AN BORD PLEANÁLA

Section 2.1 MetroLink Building Damage Assessment of Cadenza Building

Section 2.2 MetroLink Settlement Assessment at the Cadenza Building

Section 2.4 Future Extension of the Cadenza Building

TUNNEL ALIGNMENT
SAINT STEPHEN'S GREEN – CHARLEMONT
RO APPLICATION VS DEEPER VERTICAL ALIGNMENT OPTION

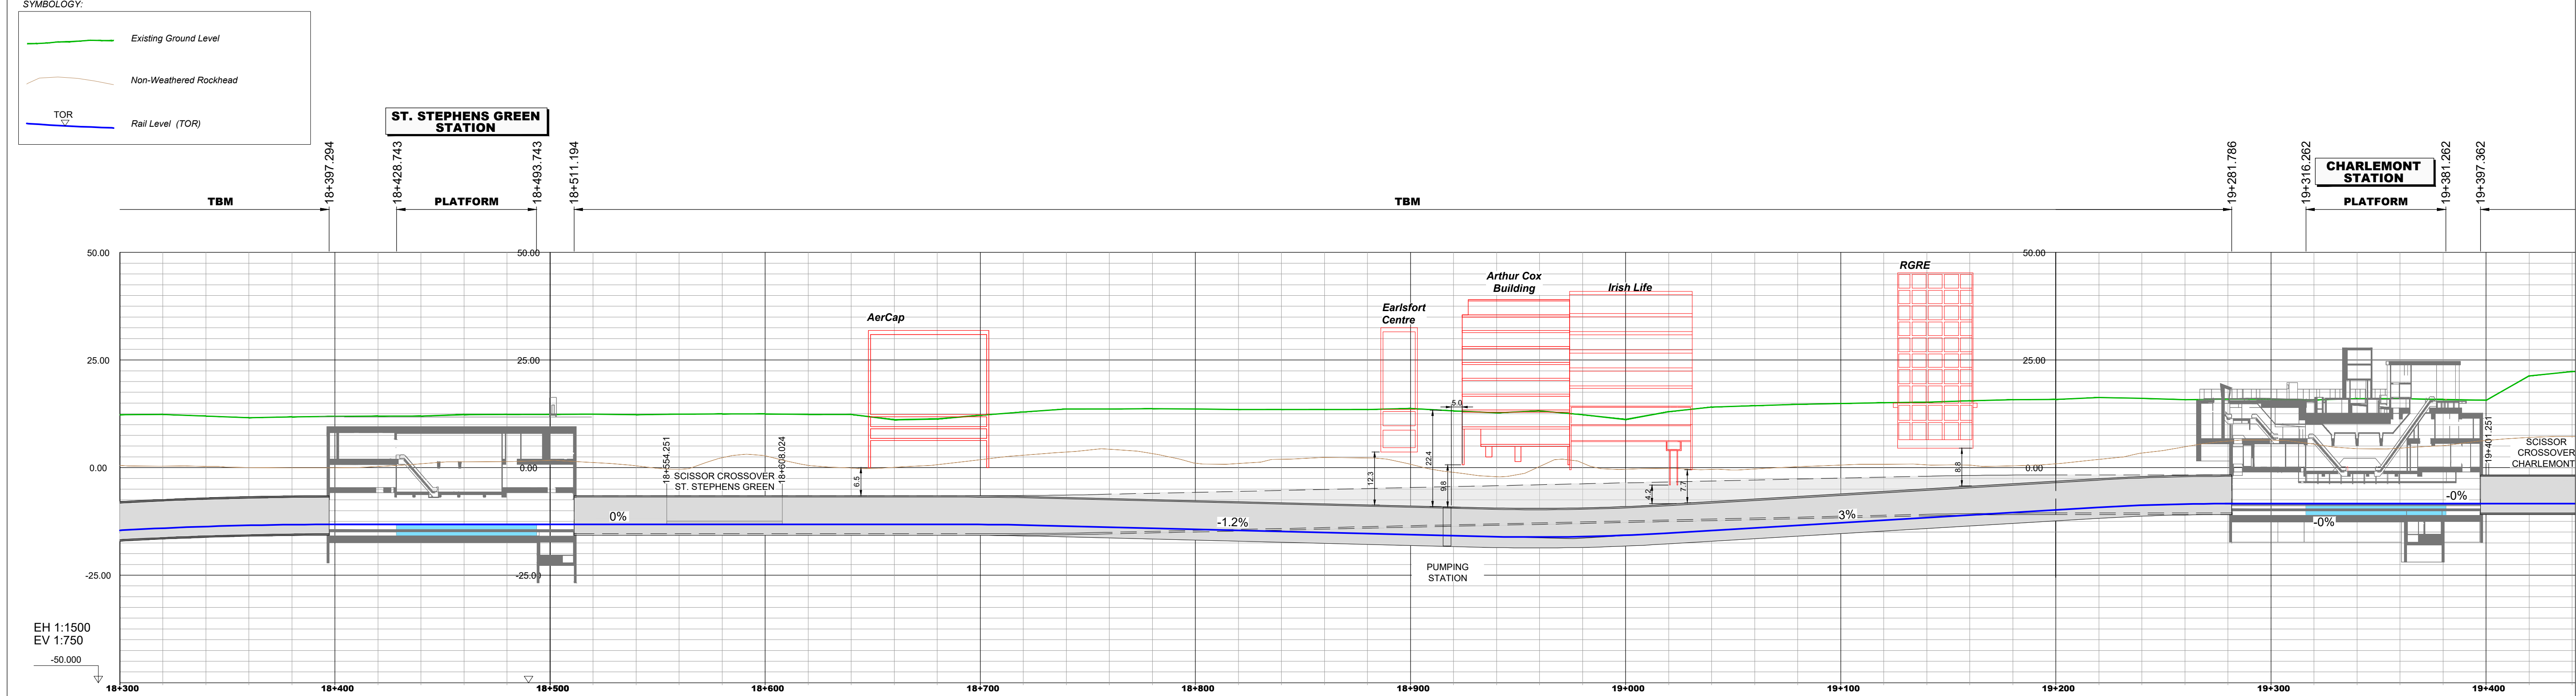
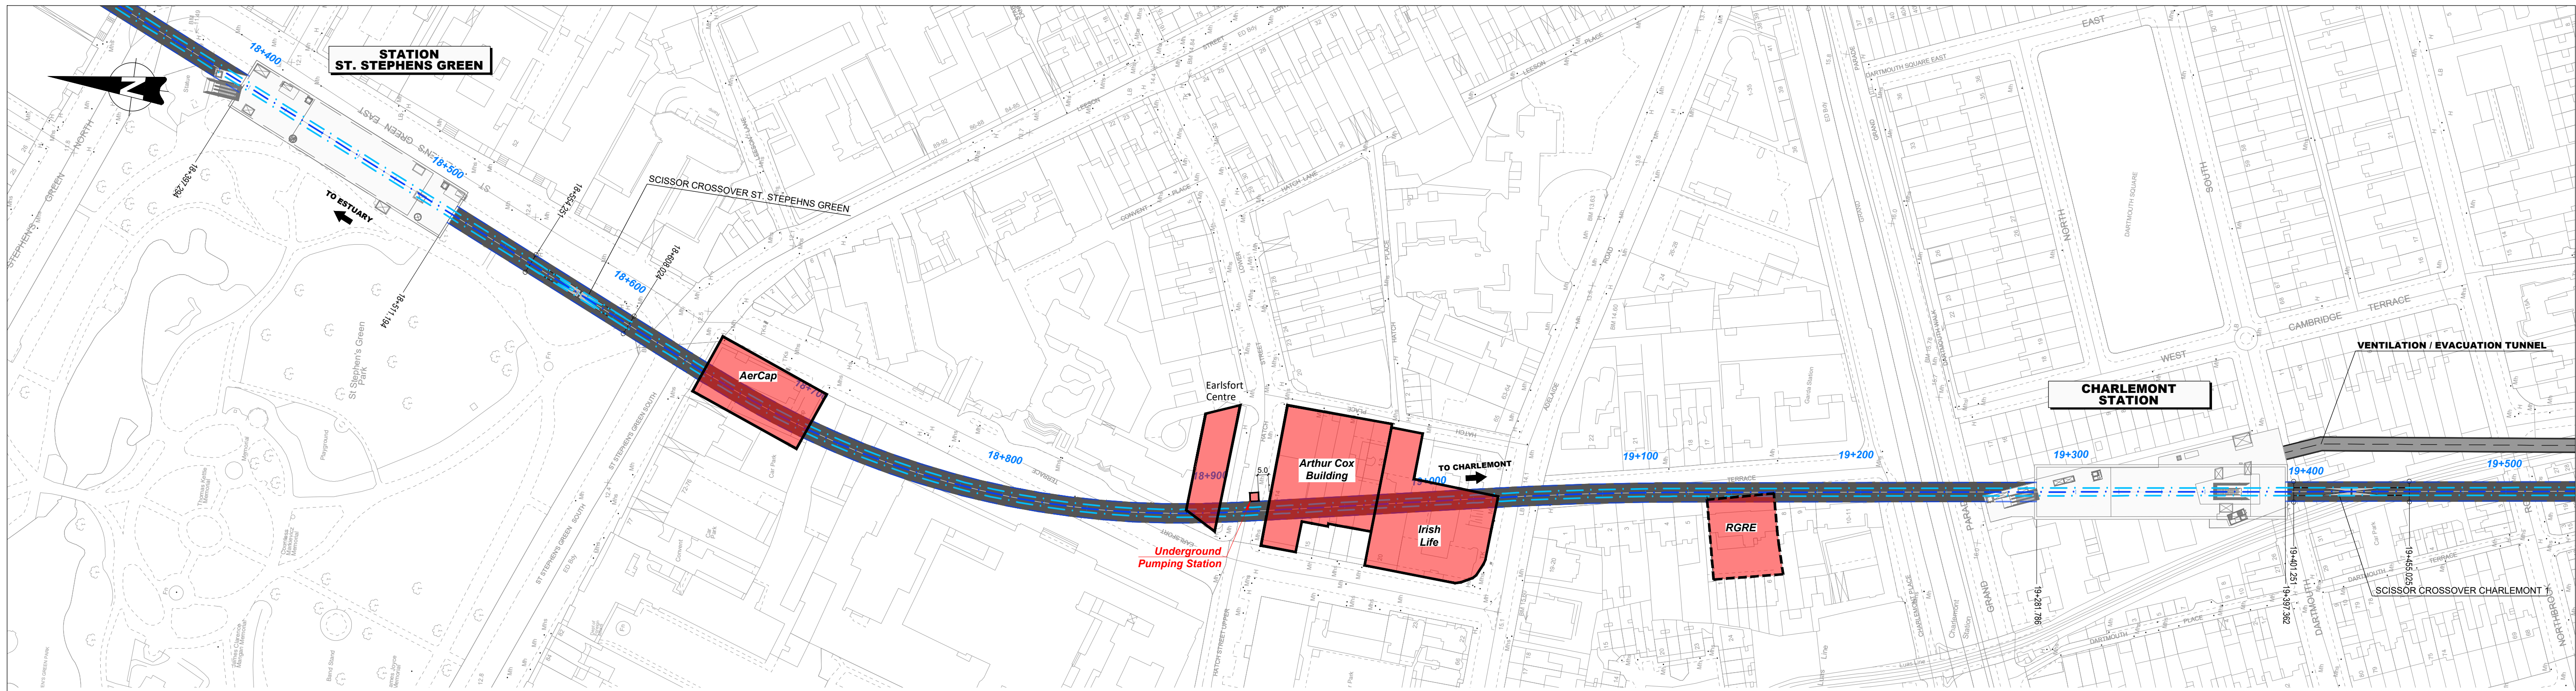
The proposed tunnel elevation may require to be lowered more than the current LOD downwards, i.e. more than the 10.0m indicated in the Wider Effects Report submitted as part of the application, considering the proximity and sensitivity of the Cadenza Building.

Based on the findings of our Report, we believe that the Metrolink Tunnel should either be:

- 1) rerouted around the substructure of the Cadenza building or,
- 2) the elevation of the Metrolink tunnel should be significantly lowered to a level that no damage will be caused to any part of the Cadenza Building.
